MEMORANDUM

DATE: August 26, 2022

SUBJECT: SF-21-033 – Saddlehorn Ranch Filing No. 2
Third Submittal

Engineering Division

SHEET 14 OF 40
JOB NO. 25142.04

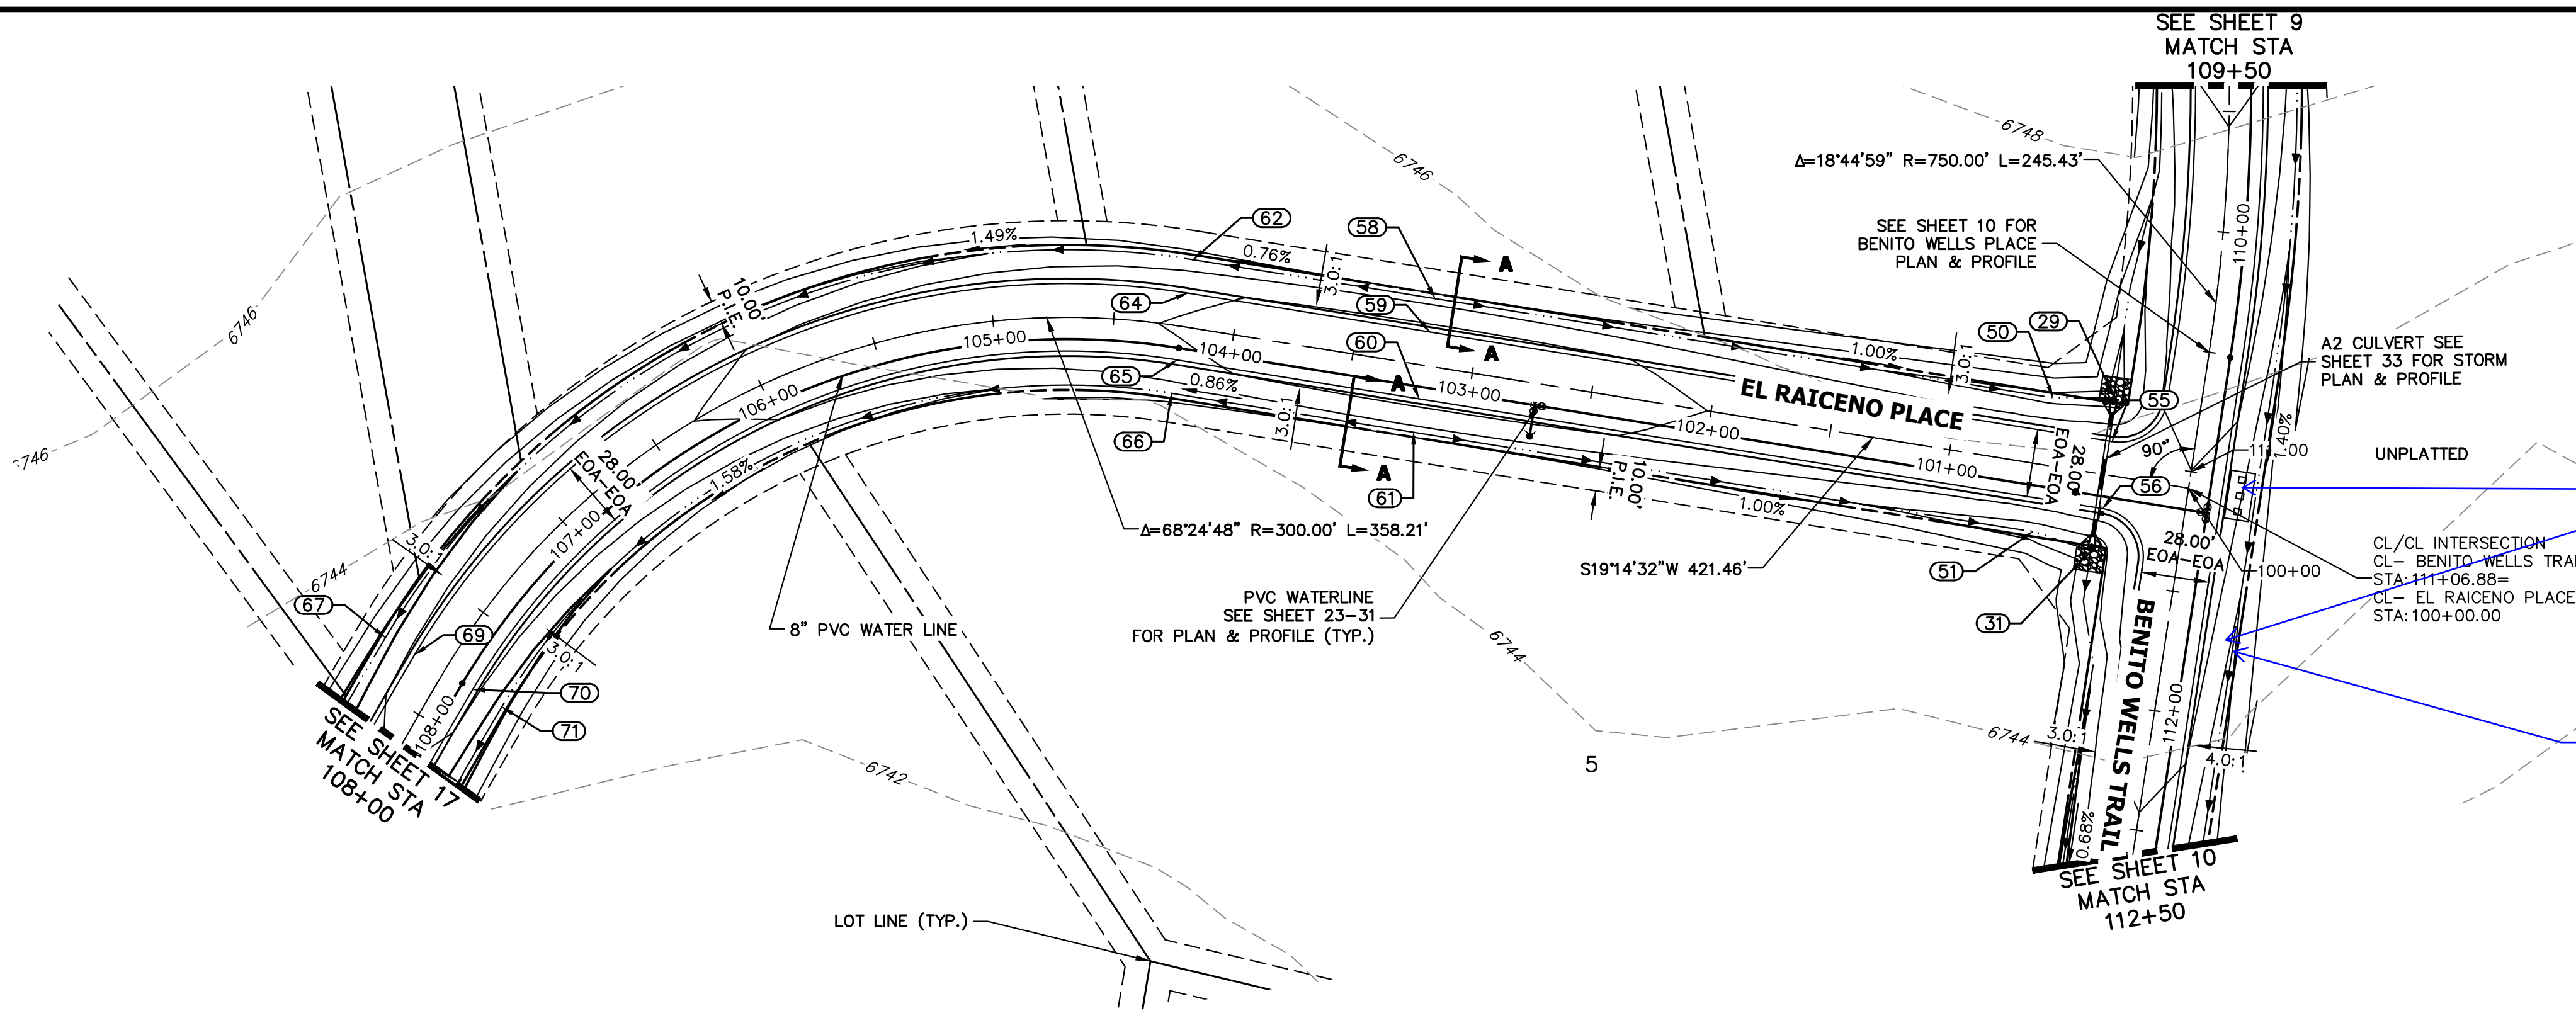
3. If there will be USPS mail kiosk/cluster in this subdivision provide location and details.
Unresolved JR Engineering Response: See sheet 10, 19, and 33 in the Construction Drawings for the location of the mail kiosk. Sheet 40 contains a detail of the mail kiosk. There's 3 kiosks spaced at 5' O.C. with capacity for 42 mailboxes.
4. **Resolved.**
5. *Resolved*
6. *Note: It is recommended that any easement documents for waterlines within future County rights-of-way allow for extinguishing of the easement(s) by plat recording and/or County acceptance of the ROW.*
